Response to:

“Summary of Submissions and Department of Planning’s Issues for the proposed Redevelopment of Twin Towns Services Club, Tweed Heads – 06_0237”.

Chris Wilson/Sally Munk 08 April, 2009

Lot 1 DP 777183 - Wharf Street, Tweed Heads
07 May, 2009 – Rev A

PROJECT No.: JOB # 335
DATE: 31.10.08
DA1-10.42 REV. A

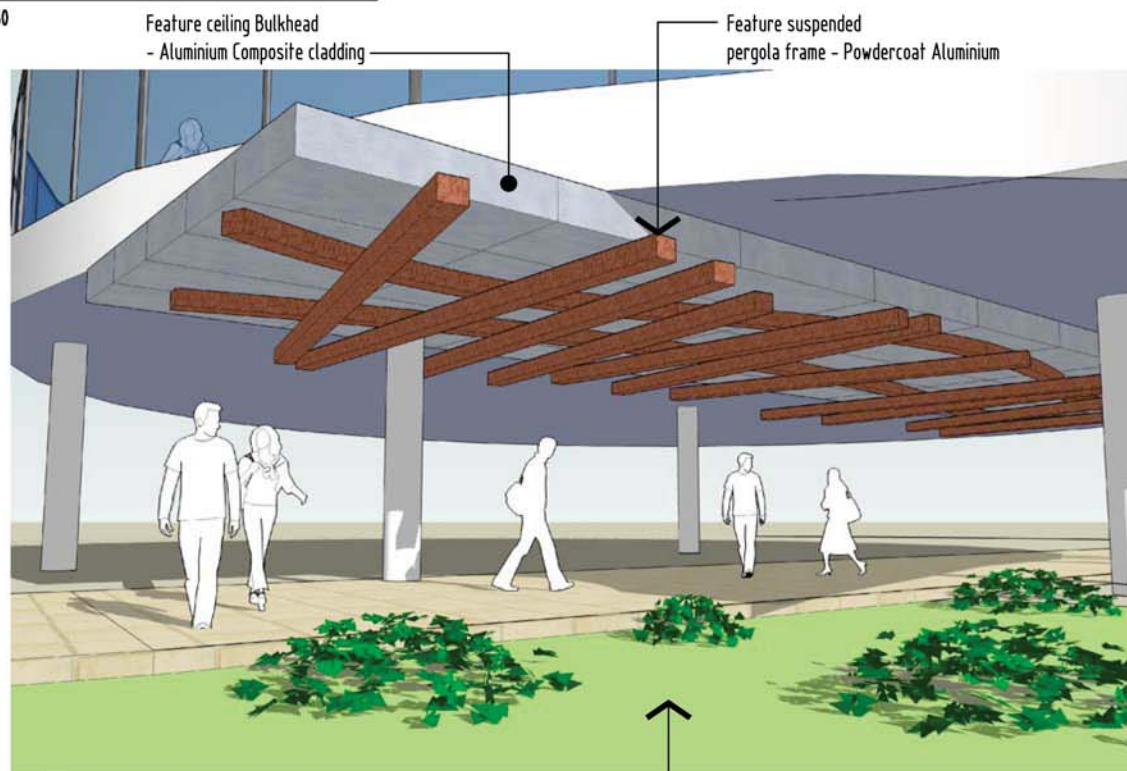
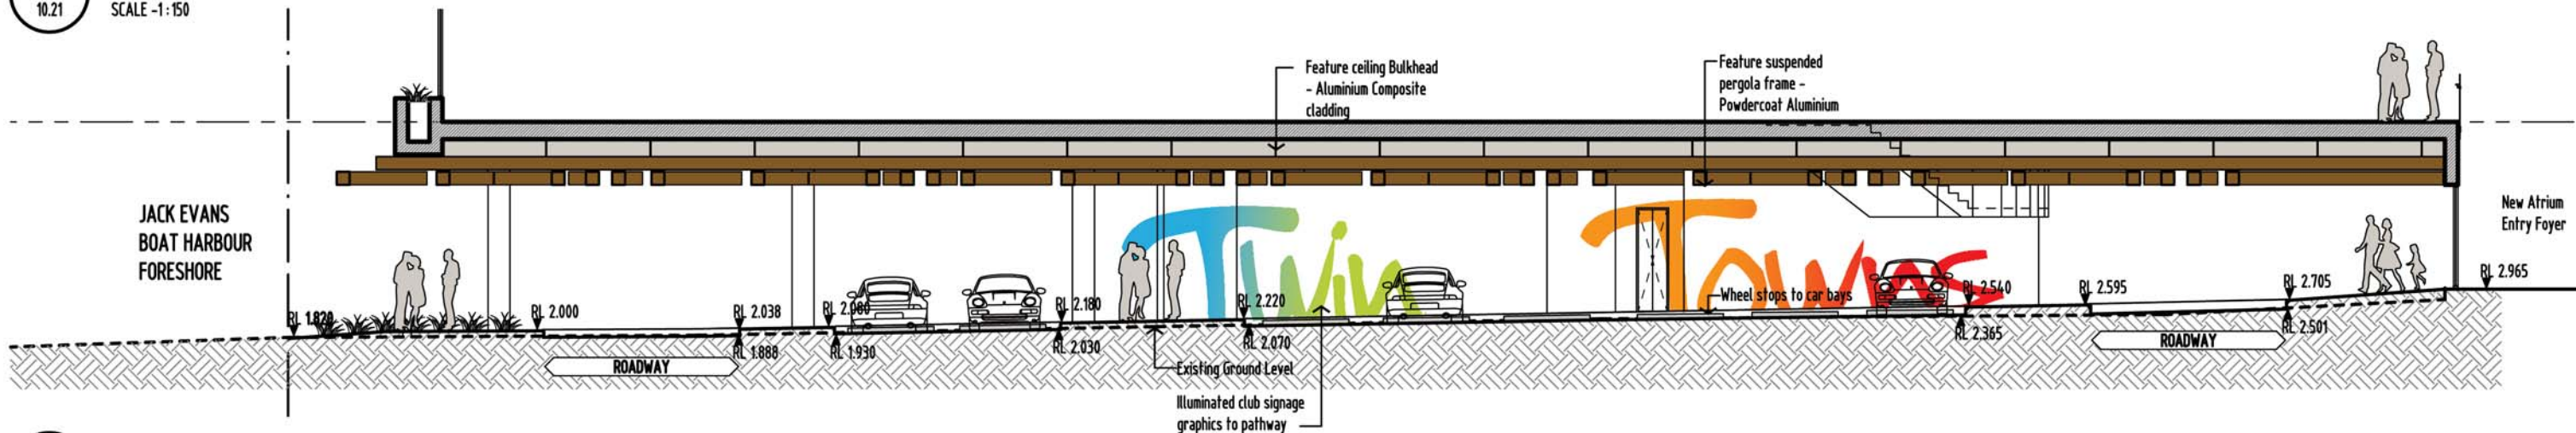
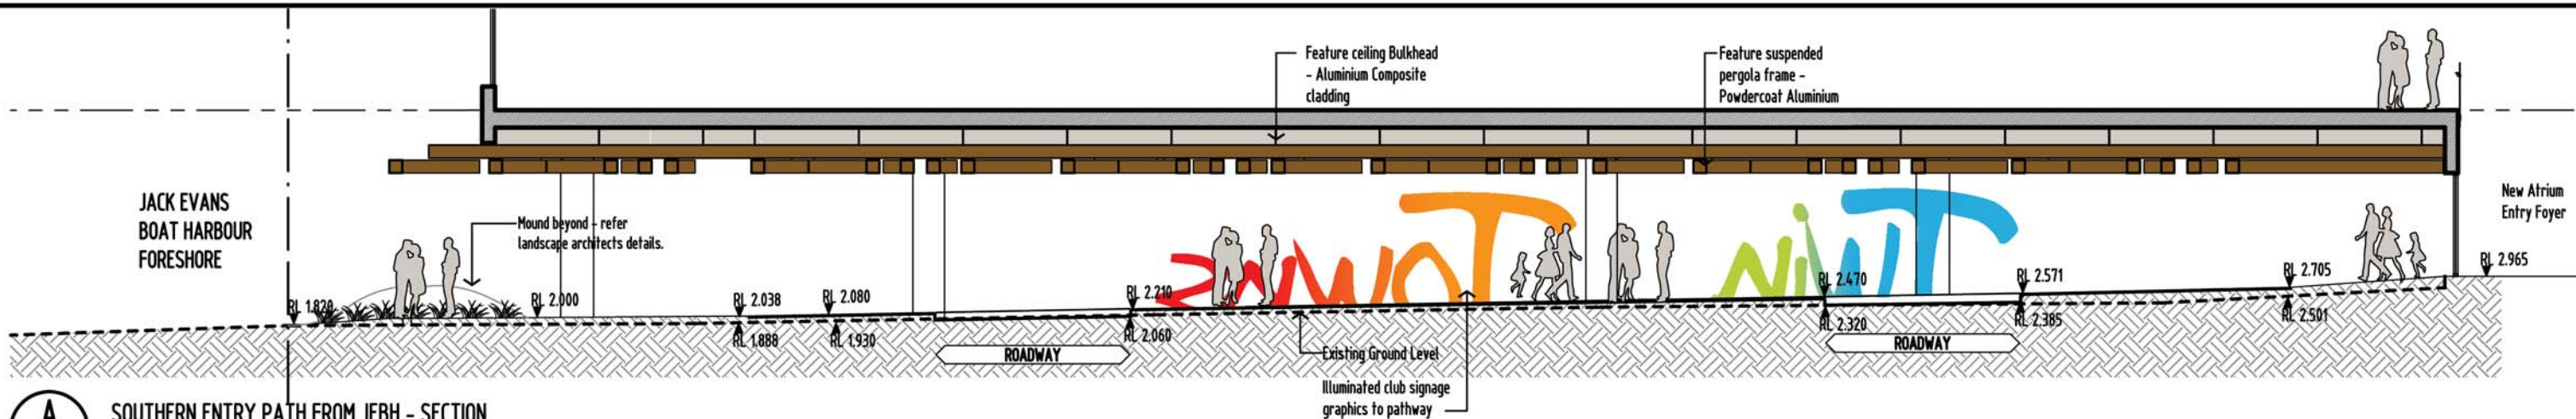
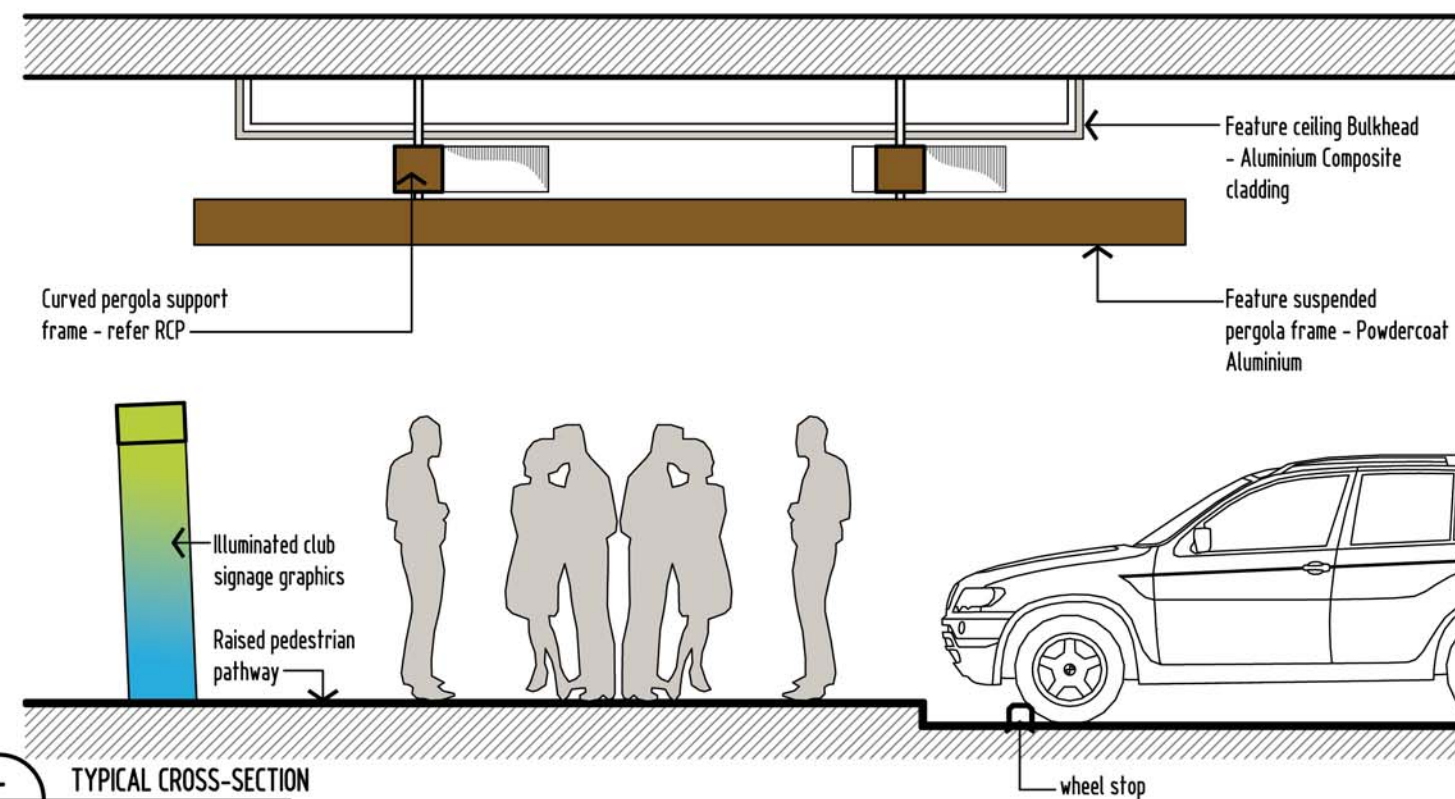
3. ***Is the pedestrian walkway through the carpark raised? It is not clear on the plans. The ADS states that it will be raised, but the plans do not reflect this. If it is to be raised, please provide a cross section that illustrates the proposed RL's.***

Please refer attached drawing DA1-10.42 for details of the raised platform indicating RL's etc.

PROJECT: TWIN TOWNS MAJOR PROJECT APPLICATION stage 2 PROJECT No.: JOB # 335
DRAWING TITLE: PROPOSED PLAN - LEVEL 4 & 5 (Mid Level) DATE: 24.04.09
CLIENT: TWIN TOWNS SERVICES CLUB DA2-10.23 REV. C

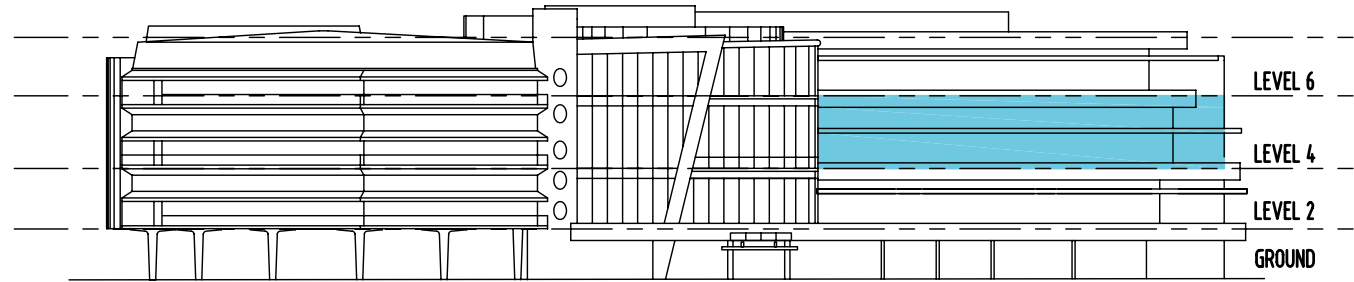
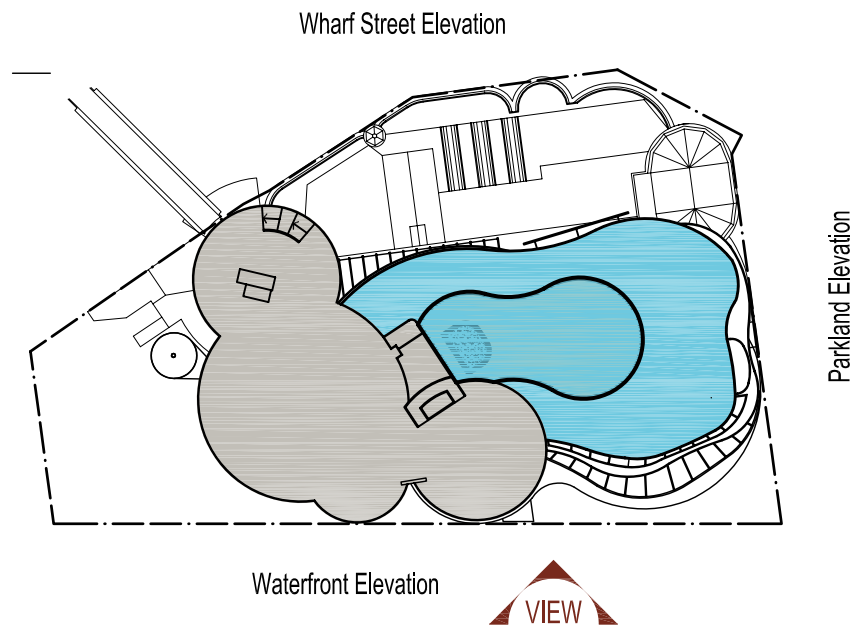
6. ***It is unclear whether guests will be able to circulate from the waterfront side of the building to the wharf street side of the building via the external terraces/balconies.***

7. ***It is not clear how pedestrians access the external terrace/balcony on the Wharf Street elevation.***

The guest balconies are focused towards the Jack Evans Boat Harbour with Back of House balconies to Wharf Street. Please refer attached revised floor plans for extents of guest balconies and back of house balconies (DA2-10.23 & DA3-10.24).

Please refer attached revised drawings indicating pedestrian access to the back of house balconies (DA2-10.23 & DA3-10.24)..

PROJECT: TWIN TOWNS MAJOR PROJECT APPLICATION stage1 PROJECT No.: JOB # 335
DRAWING TITLE: PROPOSED PLAN - LEVEL 0 (GROUND) DATE: 06.11.08
CLIENT: TWIN TOWNS SERVICES CLUB DA1-10.21 REV. B

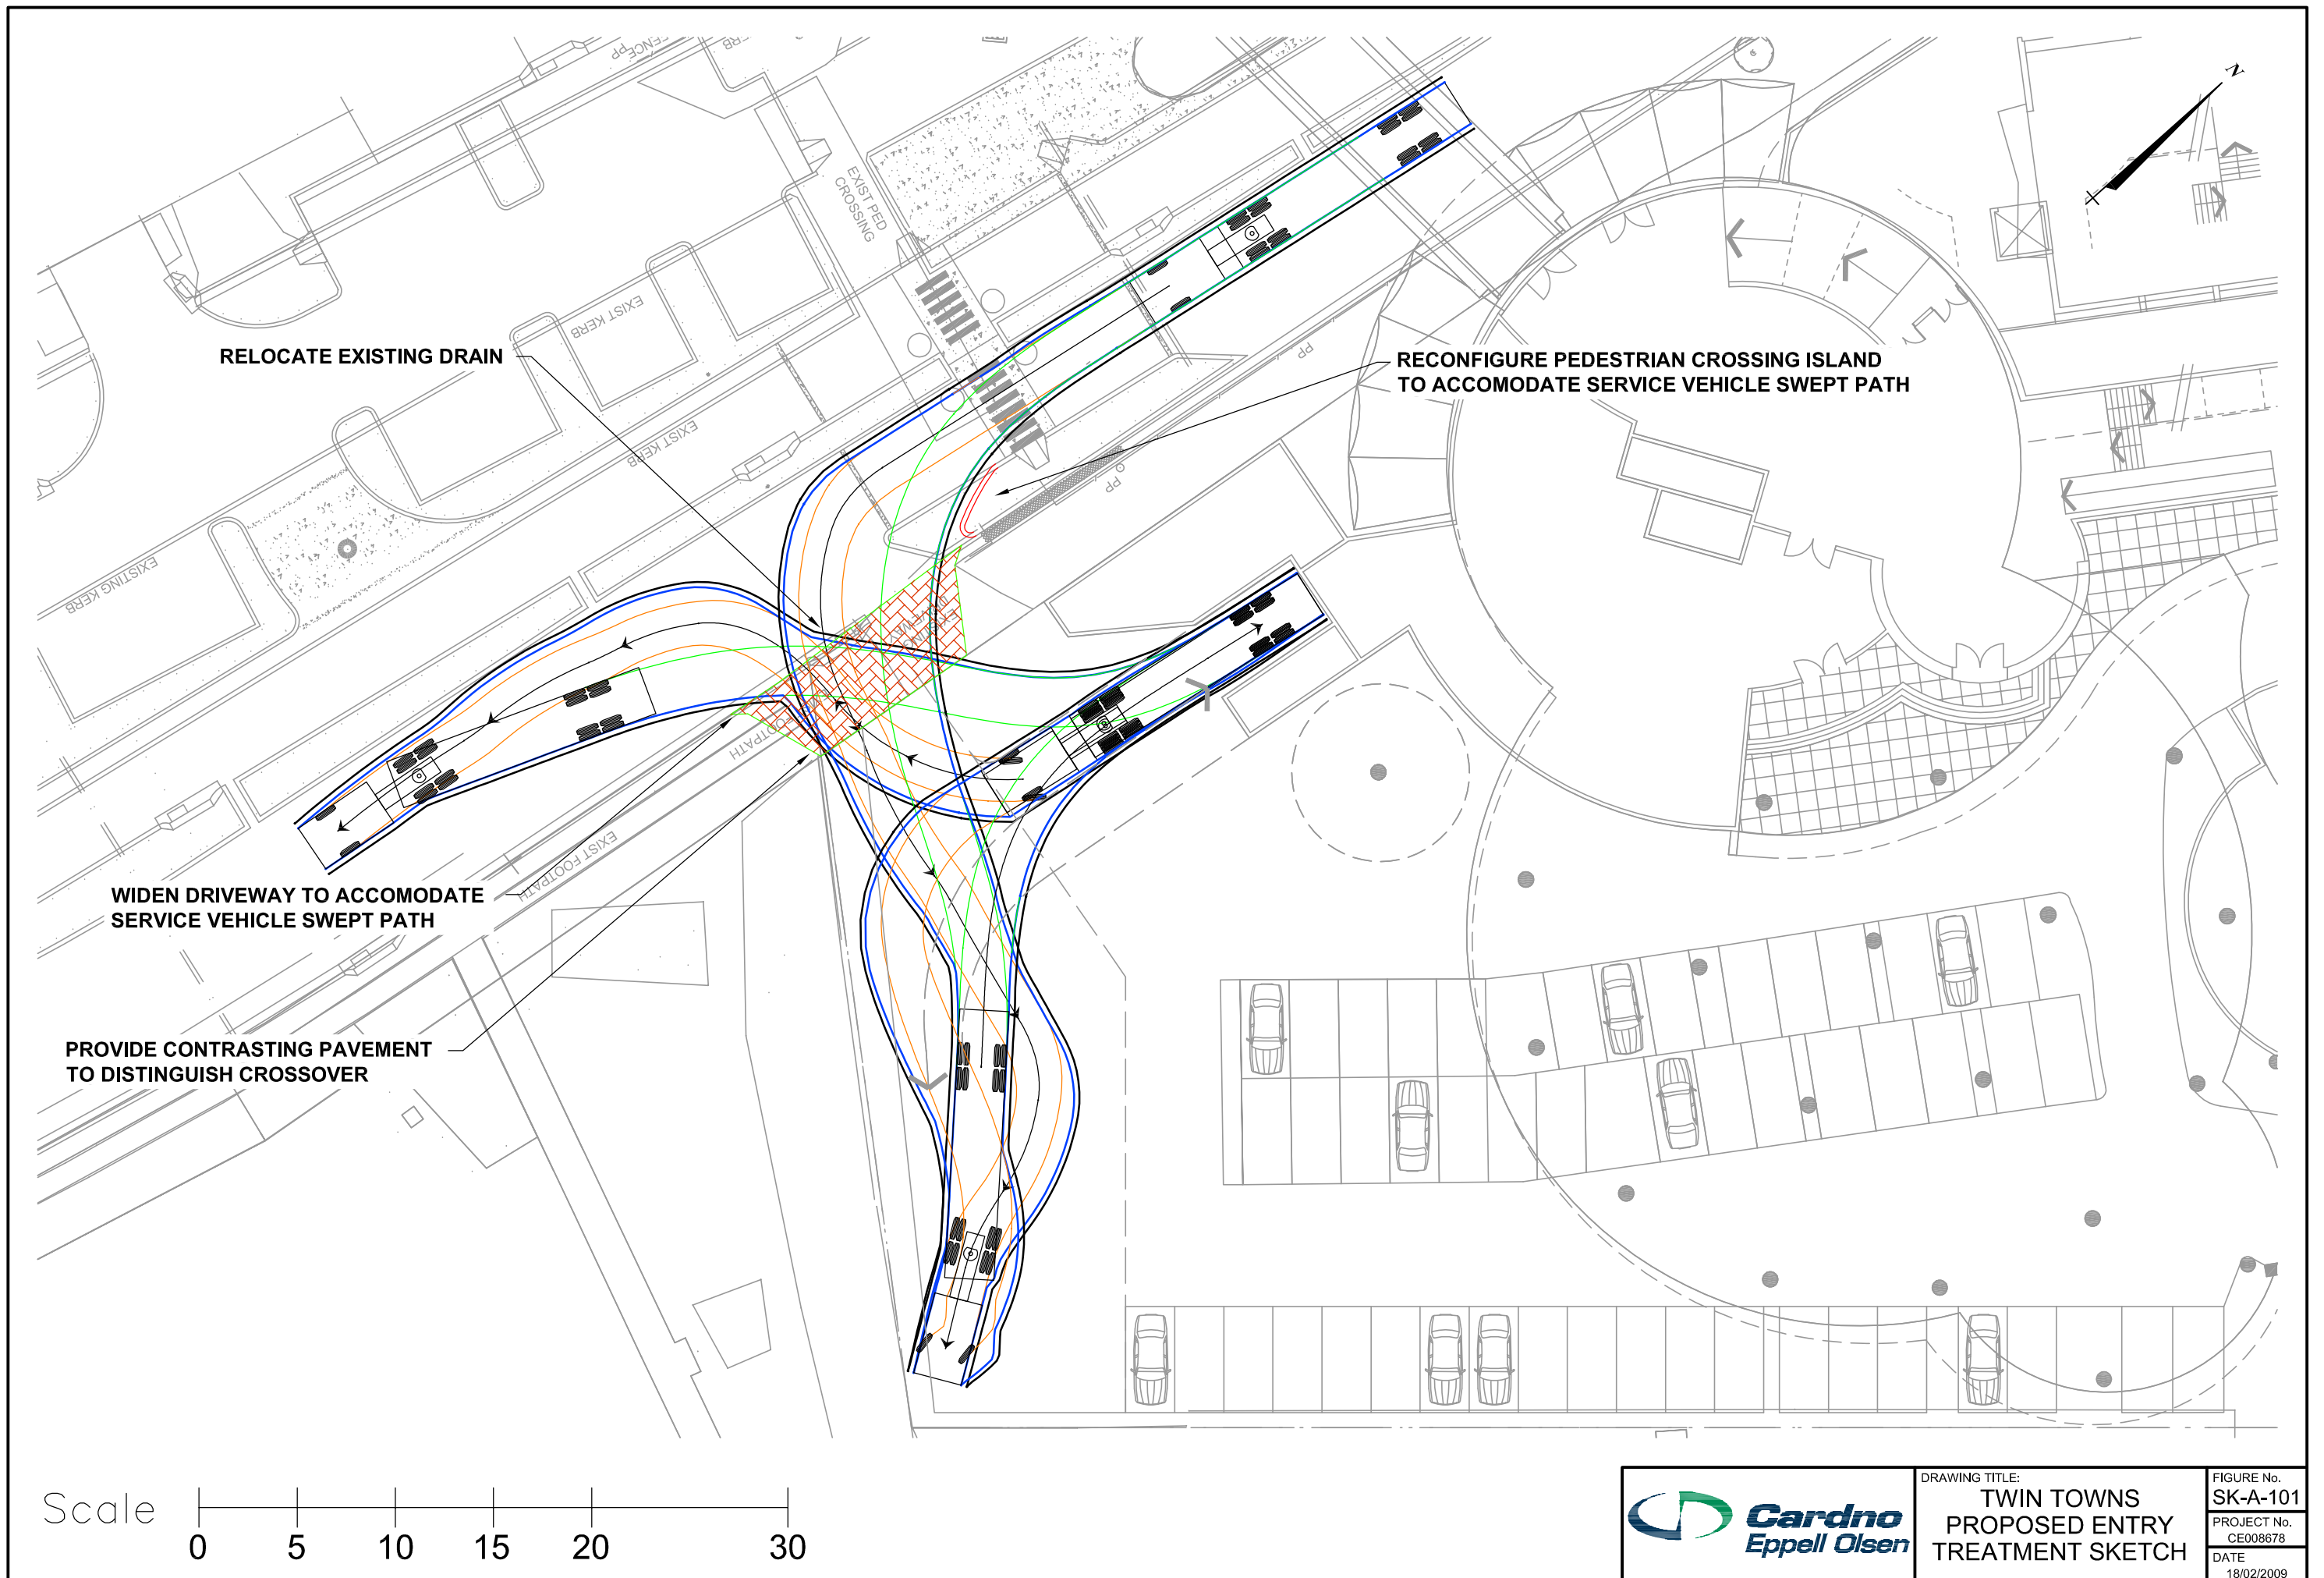
4. ***All new access points to and within the building should provide appropriate access for people with a disability having regard for section 23 of the Disability Discrimination Act 1992. Disabled parking should also be provided in appropriate locations and in number.***

Access for people with a disability will be provided in accordance with Section 23 of the Disability Discrimination Act 1992 and Australian Standard AS 1428.1. Disabled parking spaces have been indicated on drawing no. DA1-10.21 with an accessible path of travel also being provided.
